REQUEST

Current Zoning: O-2 (office)
Proposed Zoning: MUDD(CD) (mixed use development, conditional)

Approximately 1.55 acres located along the southeast side of Colonial Avenue, along the west side of Vail Avenue, and the northeast side of Randolph Road.

The petition proposes to allow medical office uses, surgery centers, medical clinics and related uses on lots constructed with a medical office building and parking, located between Randolph Road and Vail Avenue, north of North Chase Street.

RZ-100

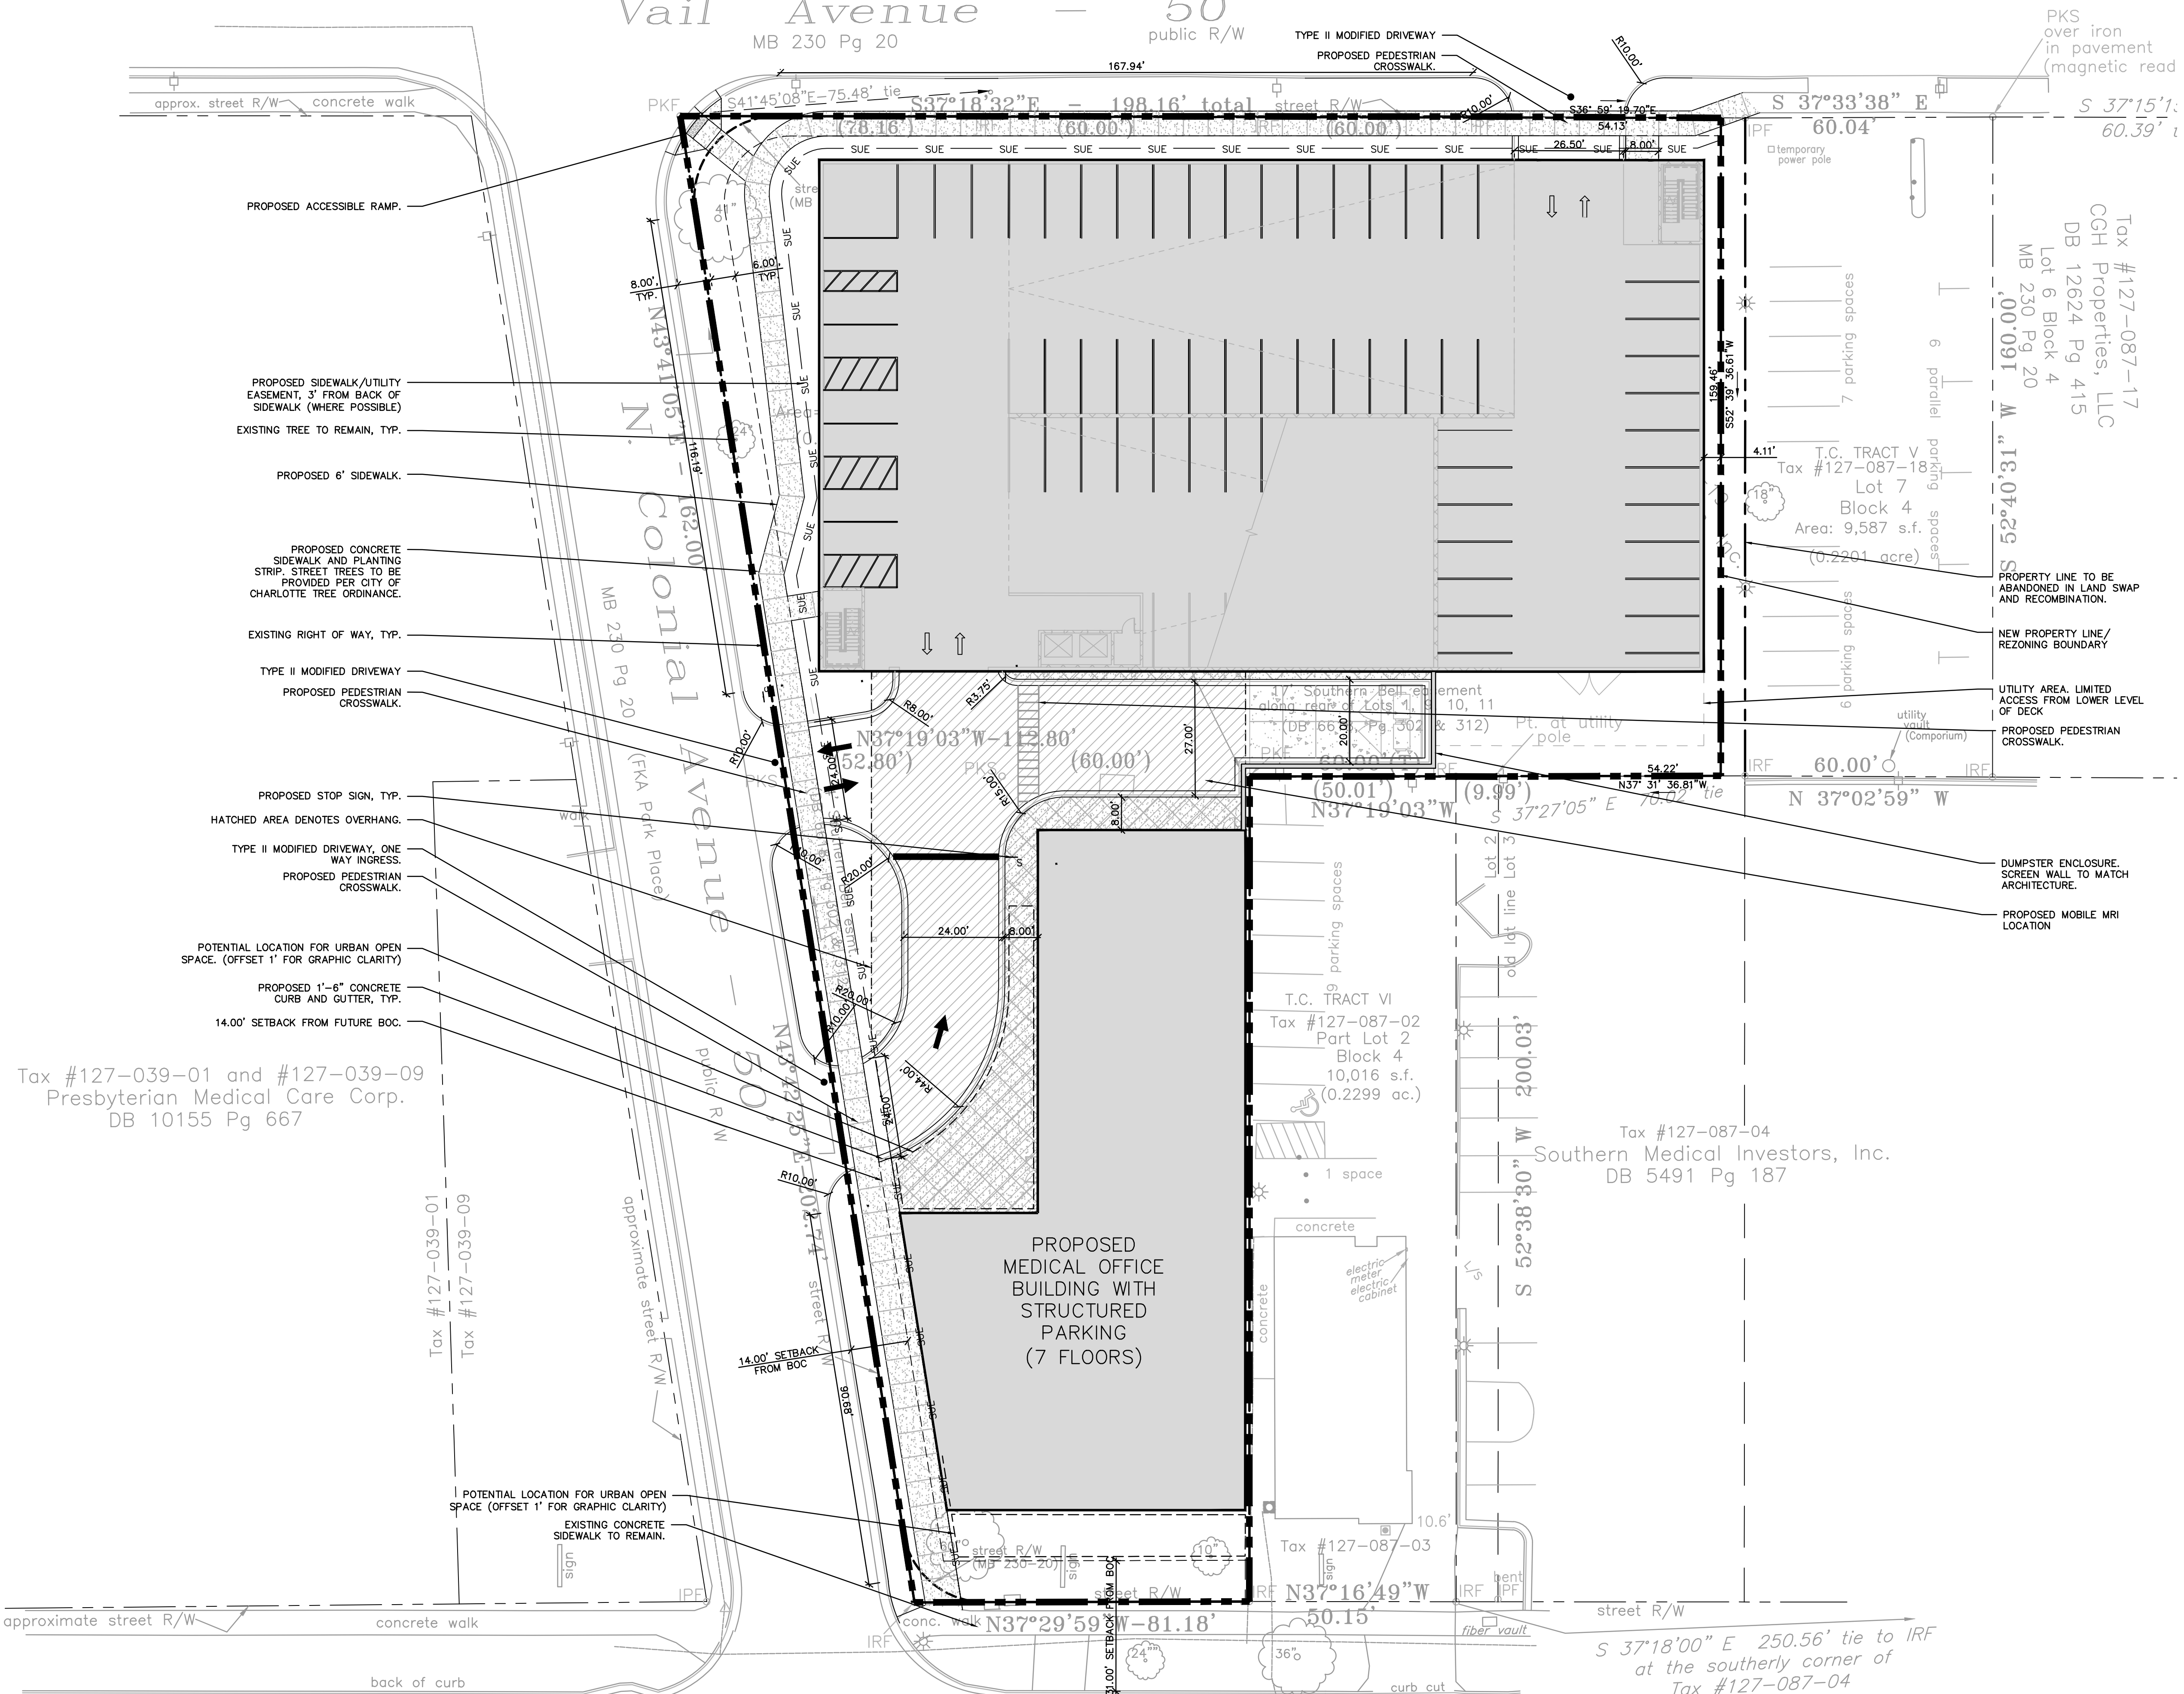
- ~~1. Under Site Development Data remove reference to number of stories.~~
 2. Label 8-foot sidewalk and 8-foot planting strip along Randolph Road and Vail Avenue.
 - ~~3. The setbacks labeled on the site plan are different from the 14' noted under Rezoning Summary. The setbacks will need to match what is shown on the site plan. **Addressed**~~
 - ~~4. On the Elevations sheet label east, west elevation (or identified street view). Signage is not part of this review. **Addressed**~~
-
